Recommendation Report for Planning Permission for Works or Extension to a Dwelling

REF NO: EP/93/14/HH

LOCATION: 12 Tamarisk Way
East Preston

PROPOSAL: Remodelling of house comprising of the removal of existing pitched roof & introduction of flat roofs together with extensions & alterations

DRAWING: PROPOSED ROOF PLAN

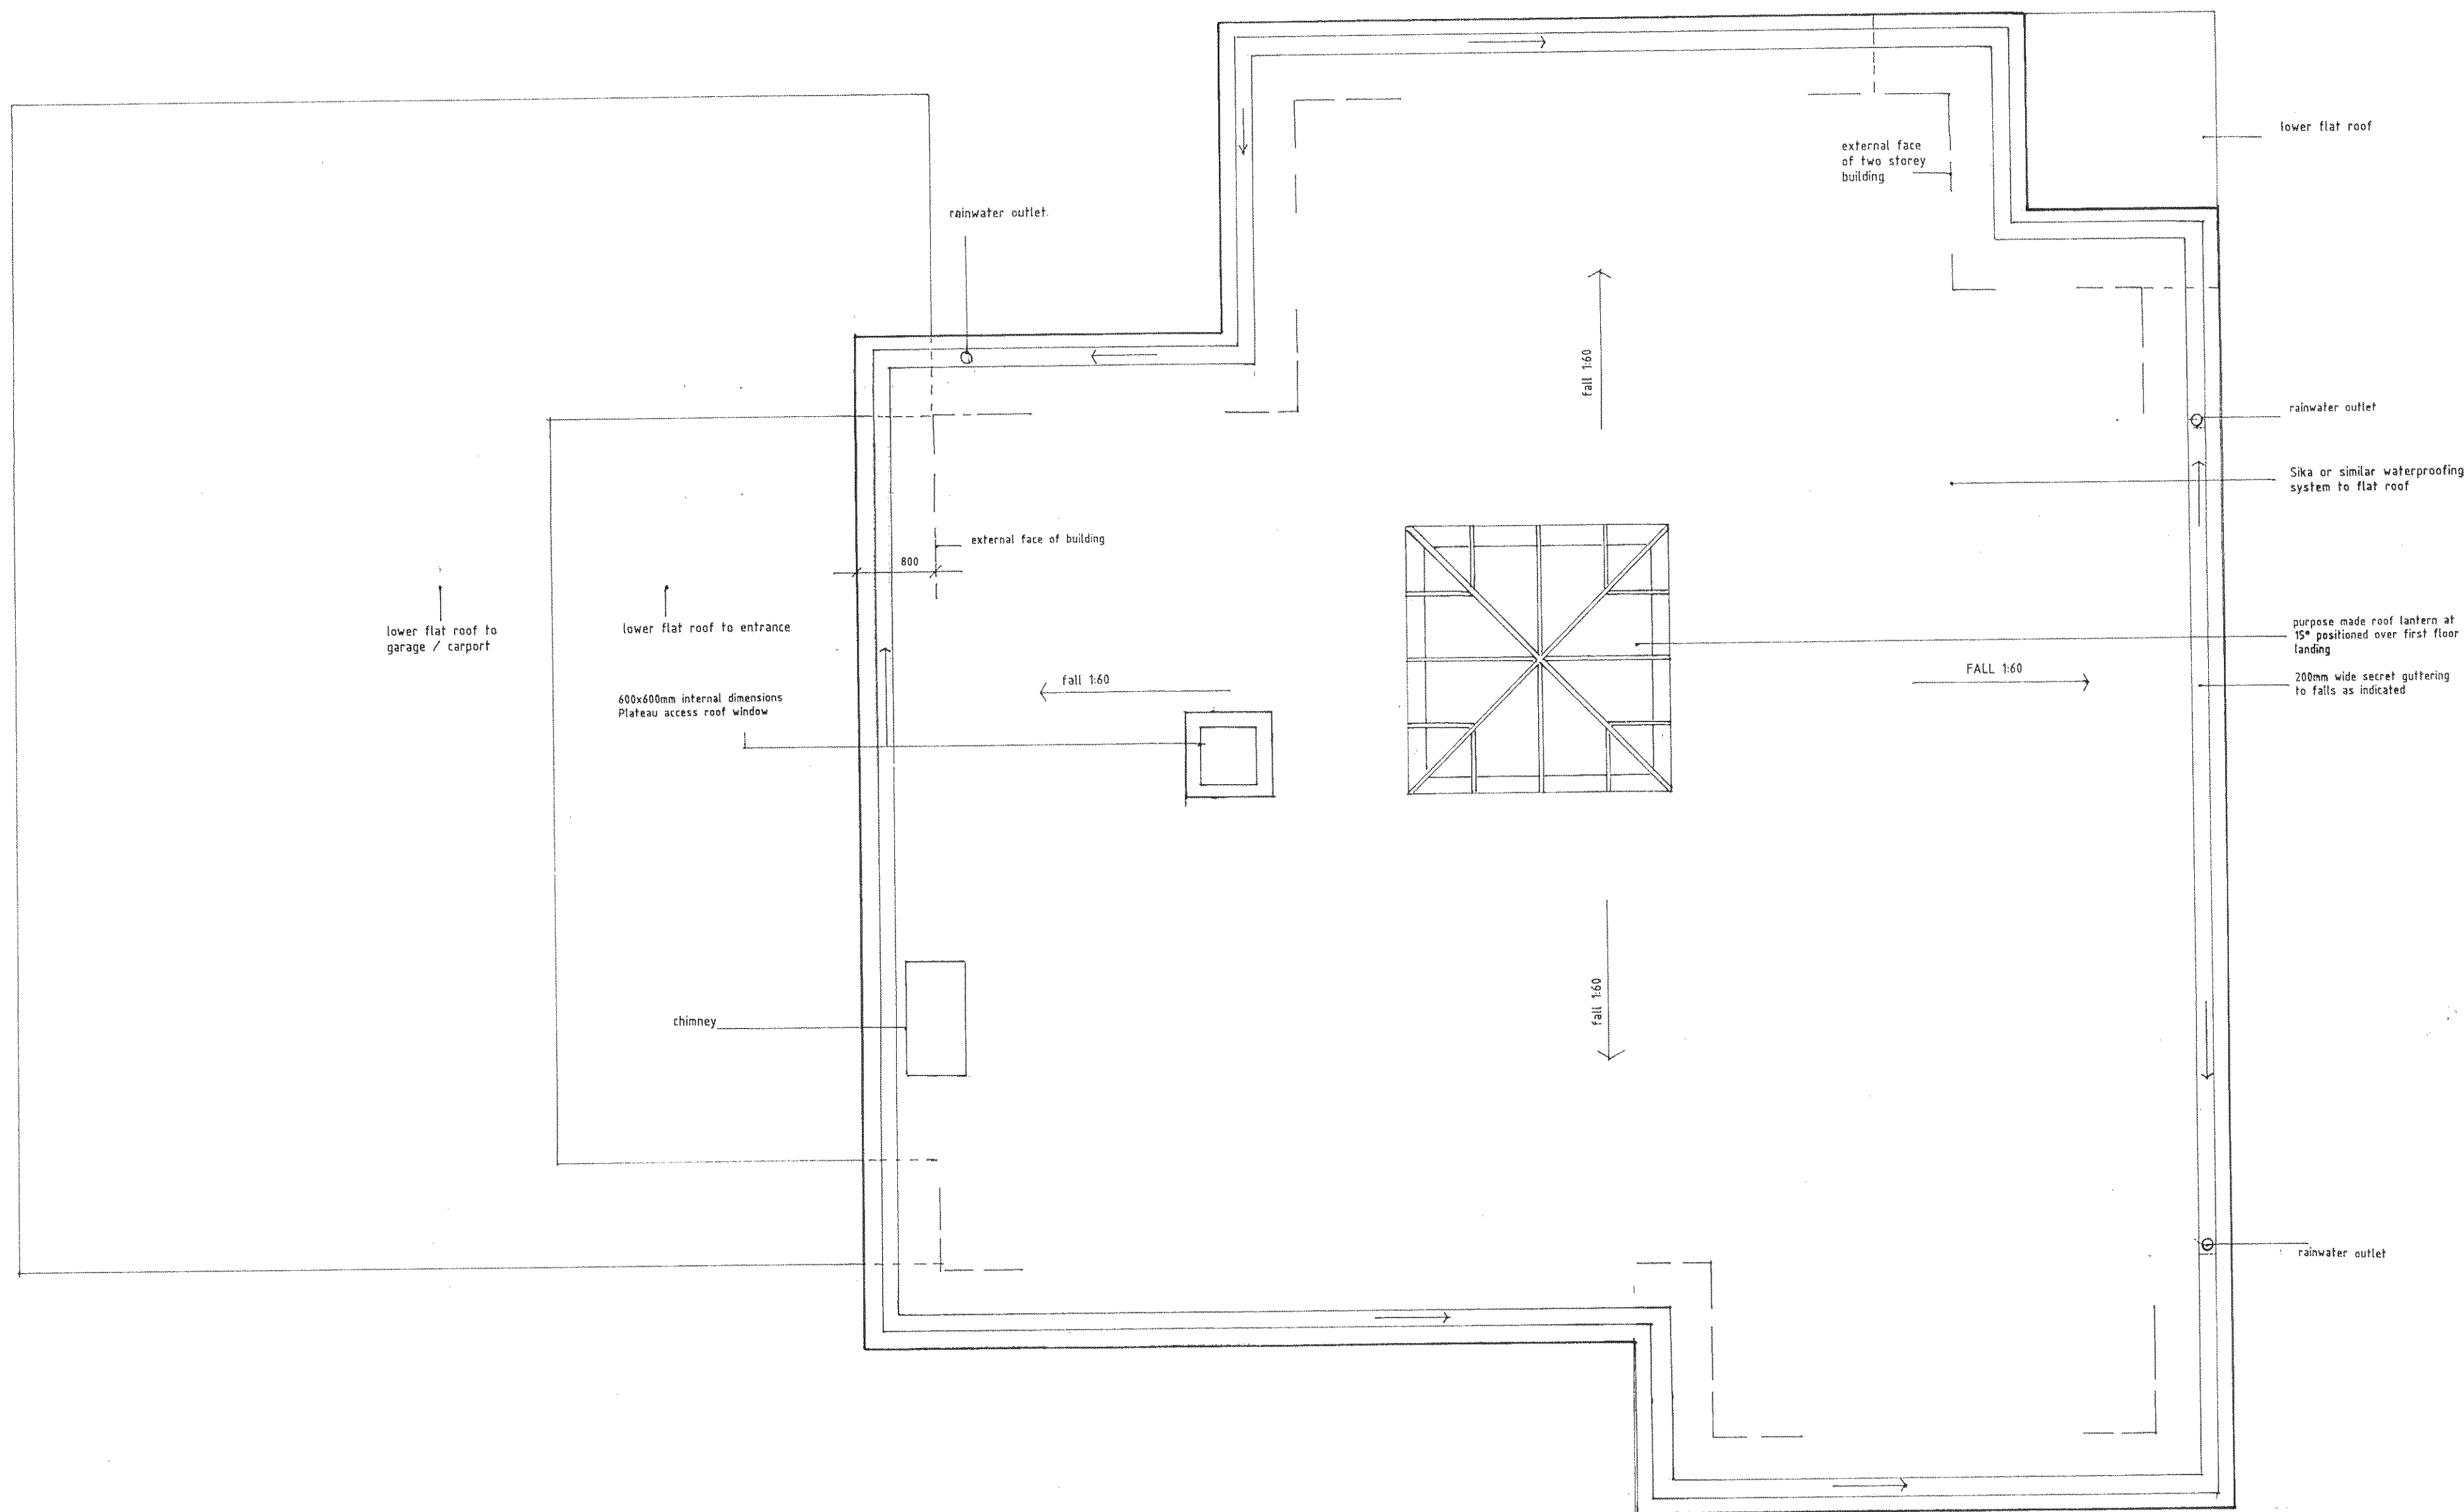
with pitched and hipped tiled roofs, in particular at Nos. 10 and 14 either side of the property and on the opposite side of the road at Nos. 7, 9, 9a and 11. In fact, the proposed form of development particularly with the introduction of a flat roof is not seen anywhere else in this section of Tamarisk Way and as such is considered to be harmfully out of character with its surroundings.

Whilst other properties are set comfortably back from the road and separated by wide grass verges and long drives, this property is in closer proximity than most and coupled with its position on a small bend in Tamarisk Way is particularly noticeable in the street scene, especially when viewed from west to east. The combination of this prominent position and the stark, alien design of development created by the extensions and alterations even though it has a lower roof height than existing would lead to a harmful appearance in the street scene and the surrounding area.
